Markup Summary

Subject: Cloud
Page Label: 13
Author: Daniel Torres
Date: 8/6/2019 8:38:46 AM
Color: ■

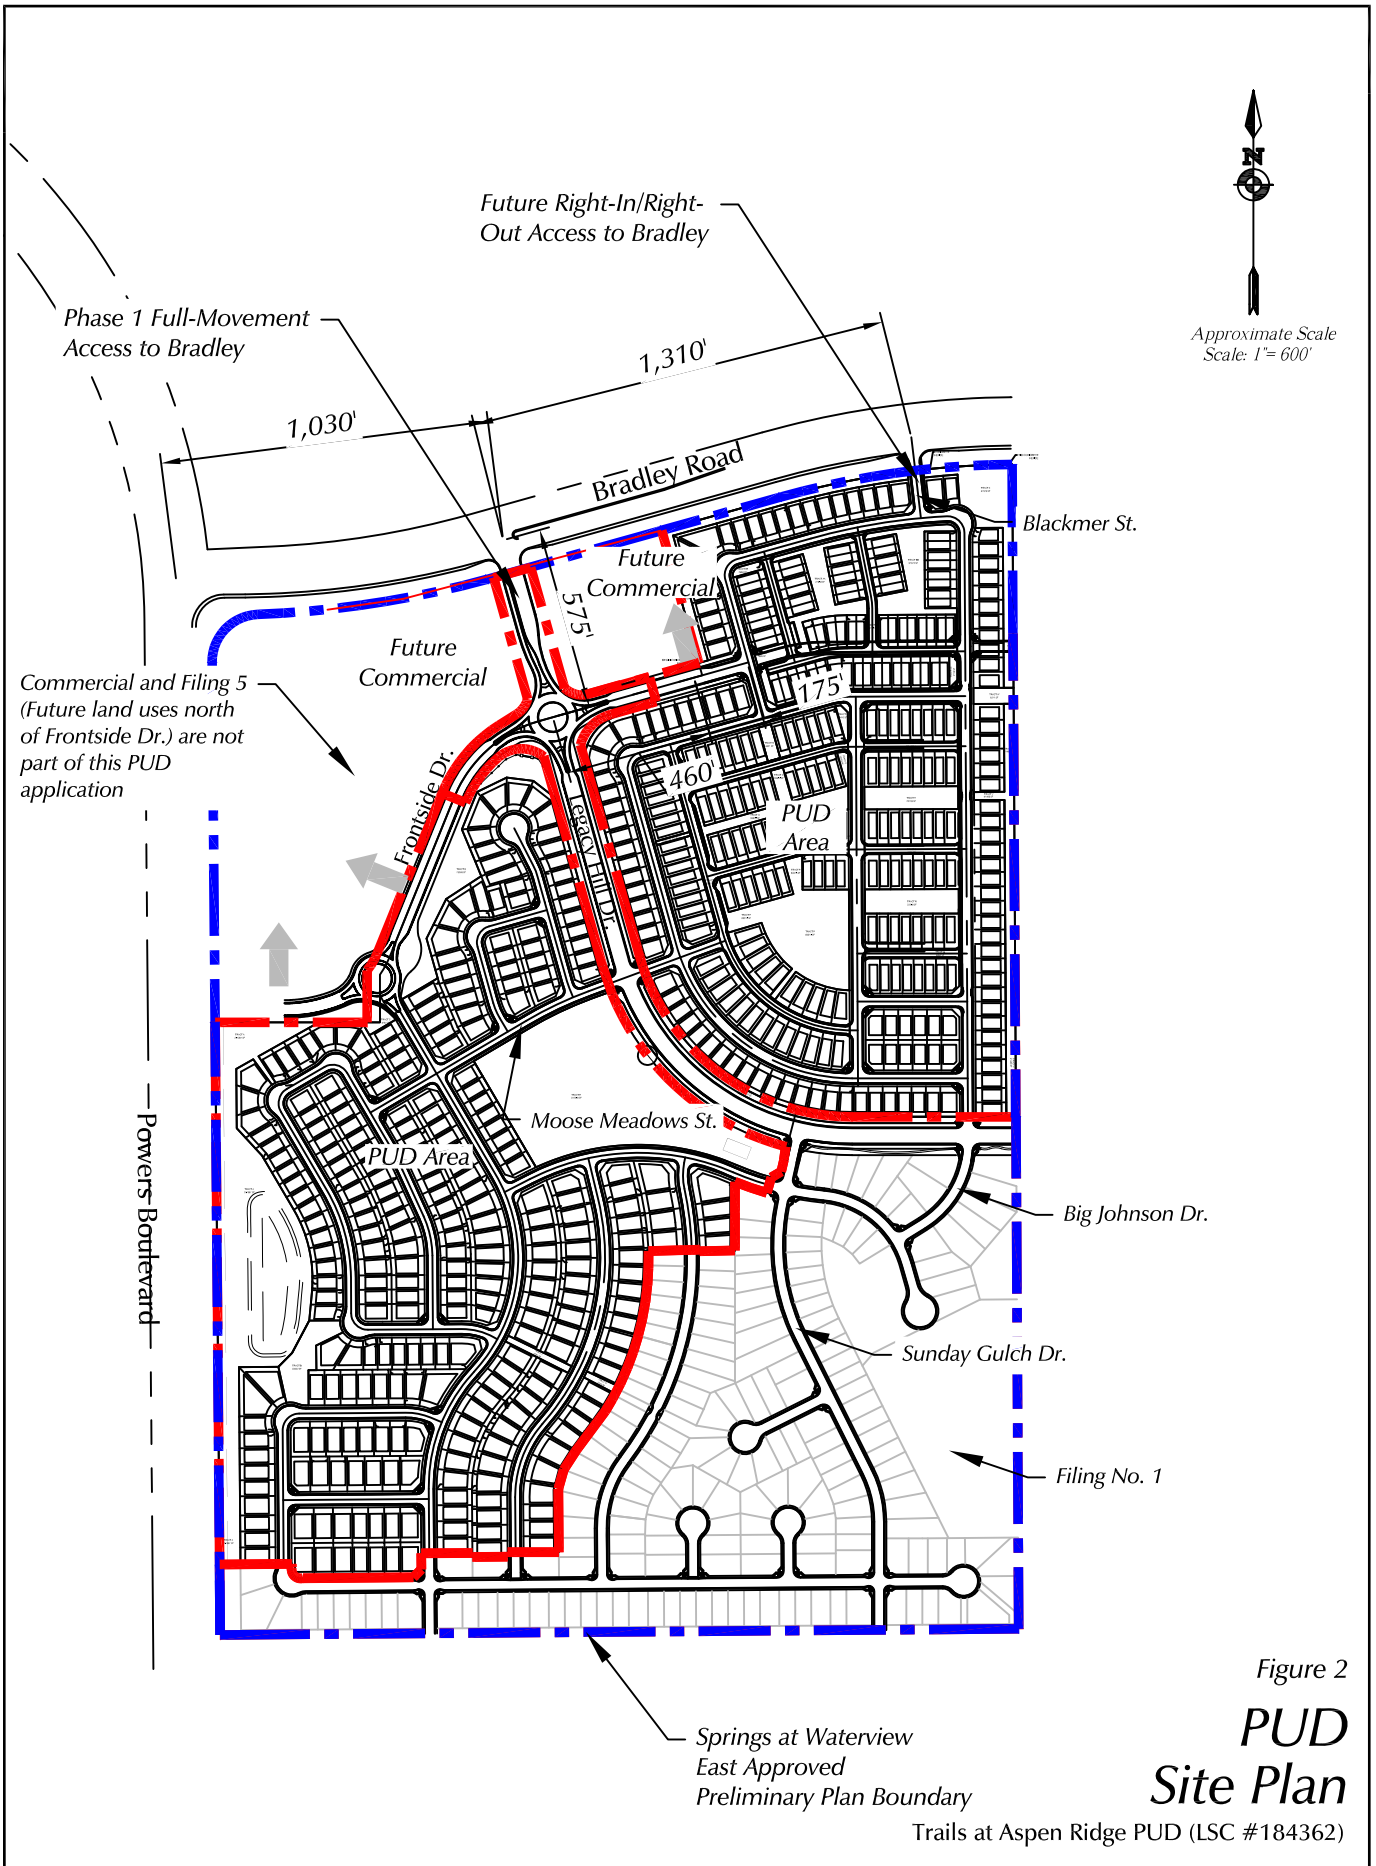
Per the County Attorney (Lori) and Transportation Planner (Victoria) this signal is not an eligible intersection improvement by virtue of Appendix 2 paragraph 3 of the Fee Program Implementation Document, which reads as follows:

A signal or roundabout will not qualify as eligible if a new development is the primary trigger for the signal or roundabout warrant and the primary purpose of the signal or roundabout is to control access to and from that development.

Condition of approval number 5 for the approved Springs East at Waterview (SP-17-010) remains which states:

Each final plat shall deposit into an escrow account its fair share contribution toward the construction of a traffic signal at the intersection of Bradley Road / "A" Street. FYI: "A" Street is now identified as Legacy Drive in the final plat.

Provide the prorated escrow amount for the Legacy/Bradley signal and the Powers/Bradley existing signal.

Identify the required right turn and left turn lane lengths.

The applicant is including these improvement with filing 1. Update the narrative to identify whether or not there is a safety concern with installing the turn lane prior to the 50 vph trigger.

Figure 5

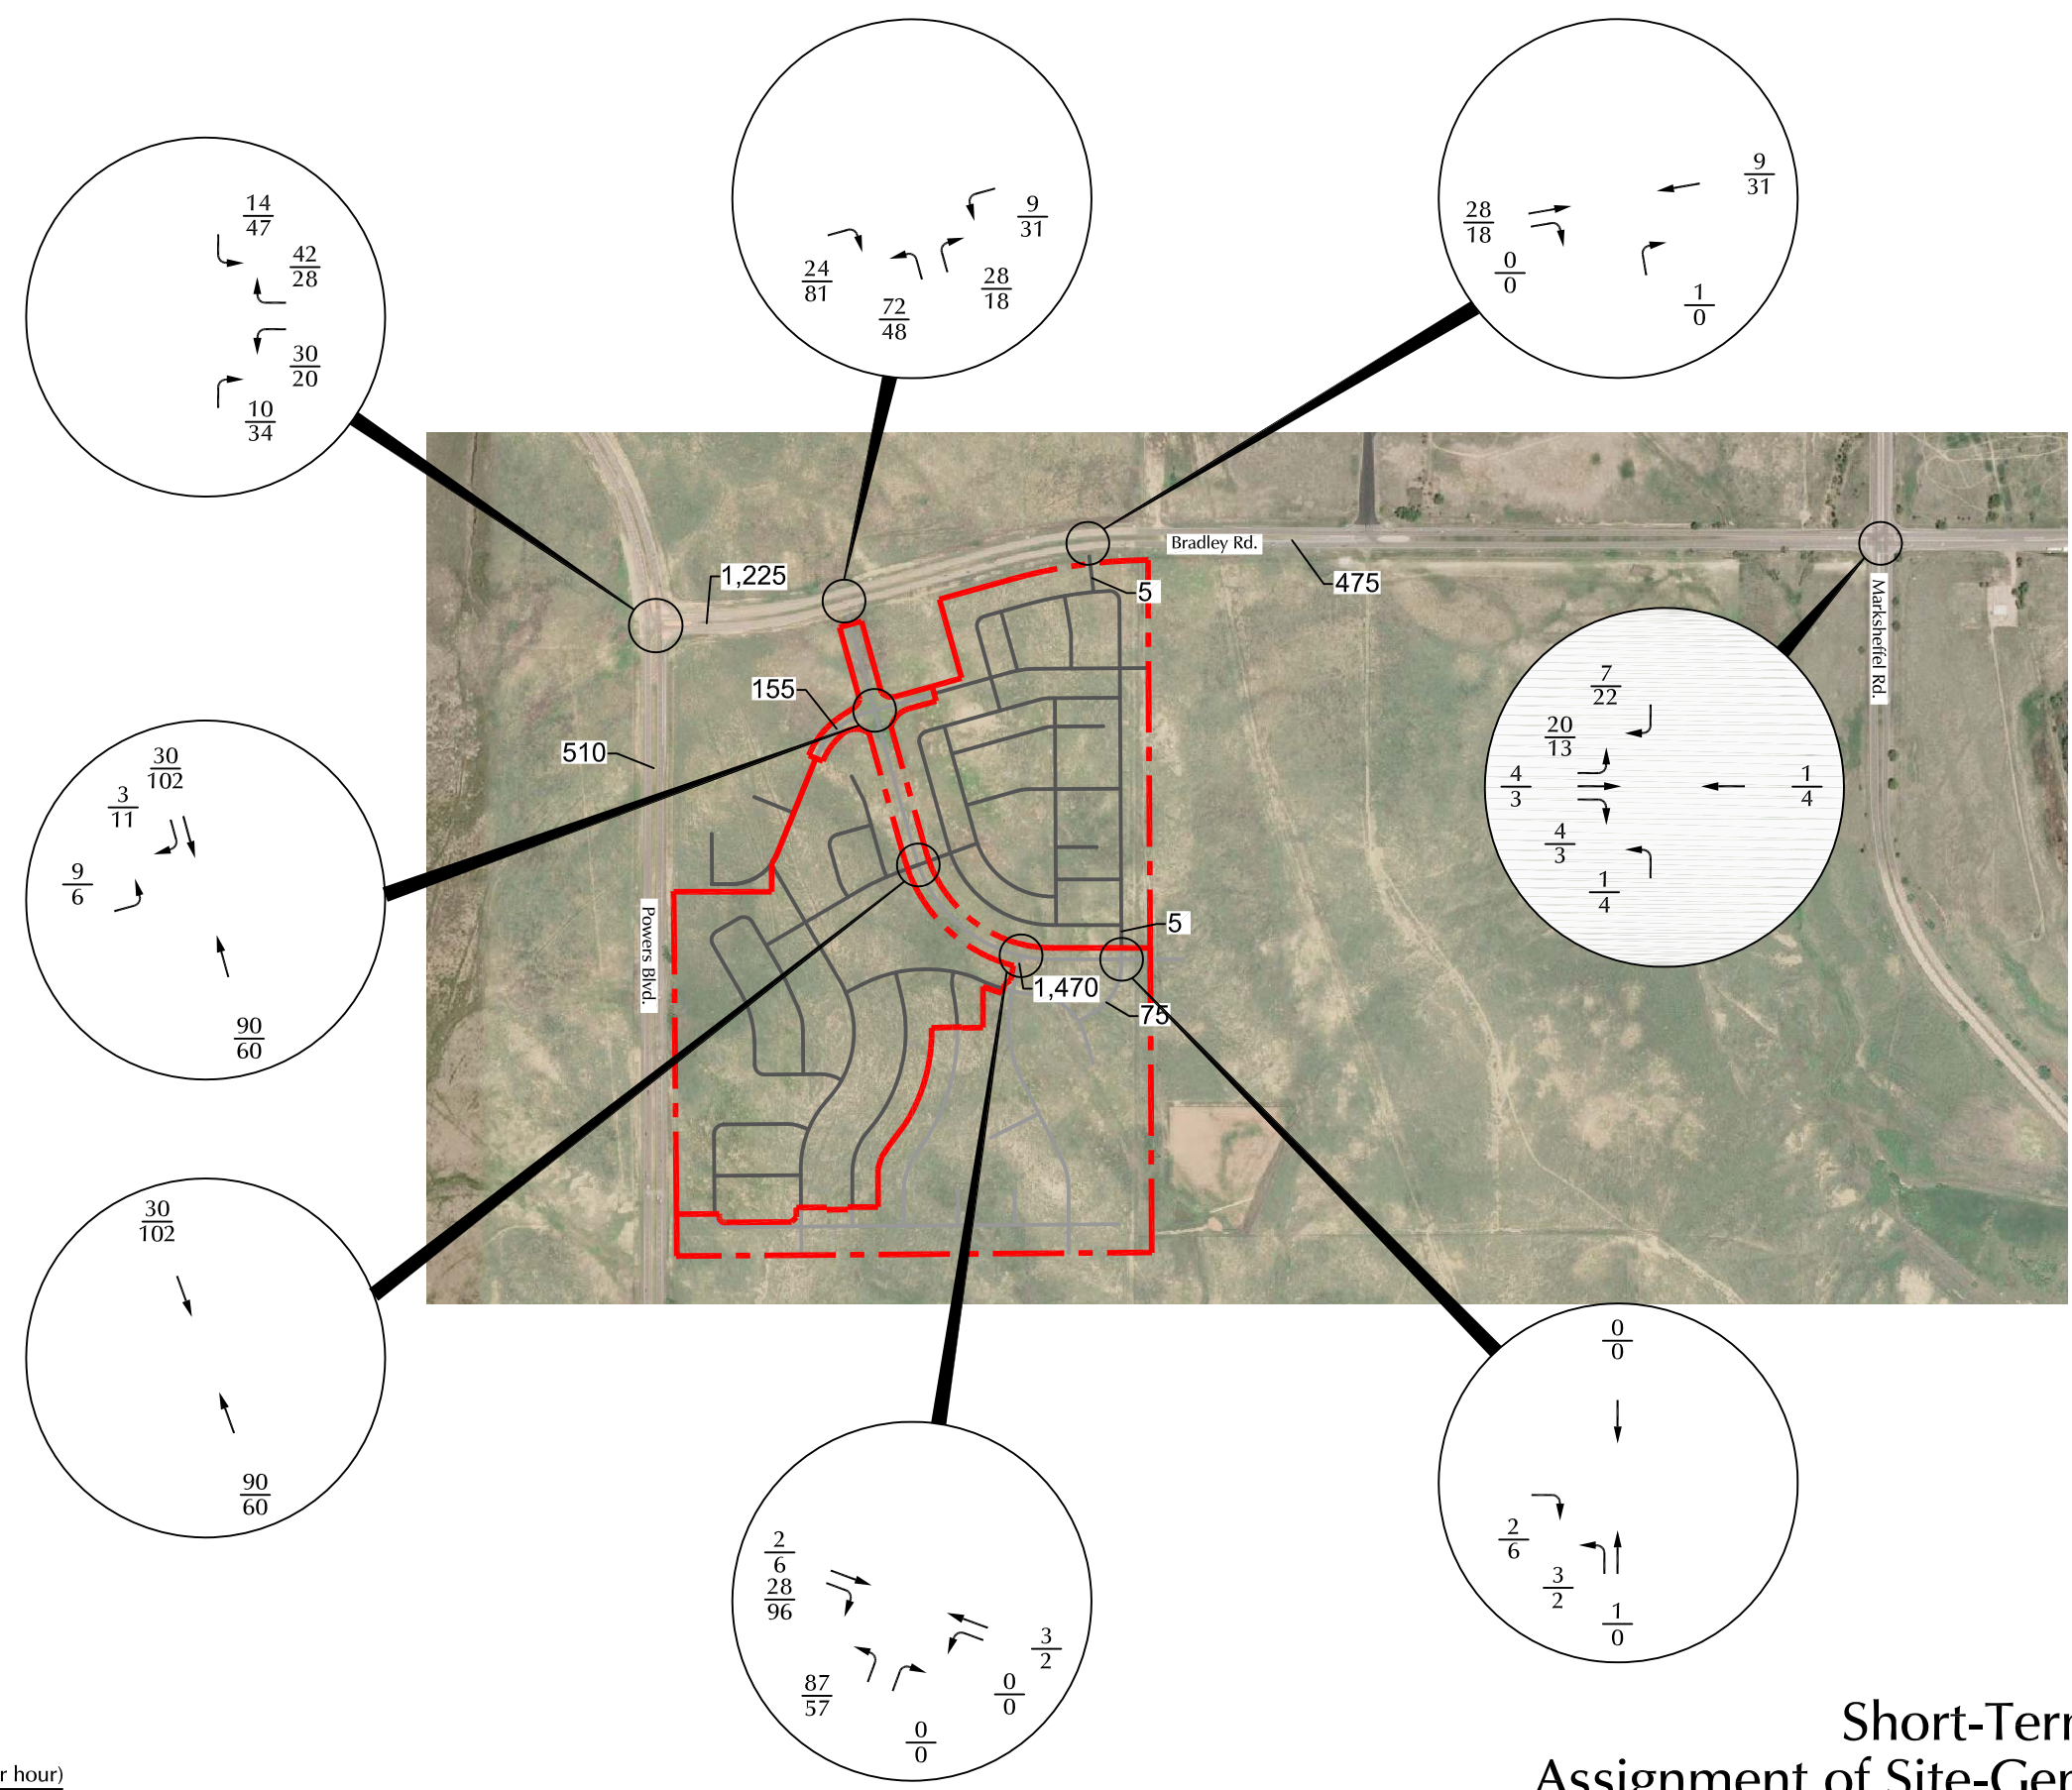
Figure 5 is the Directional Distribution. Figure 3 shows Existing traffic. Revise accordingly.
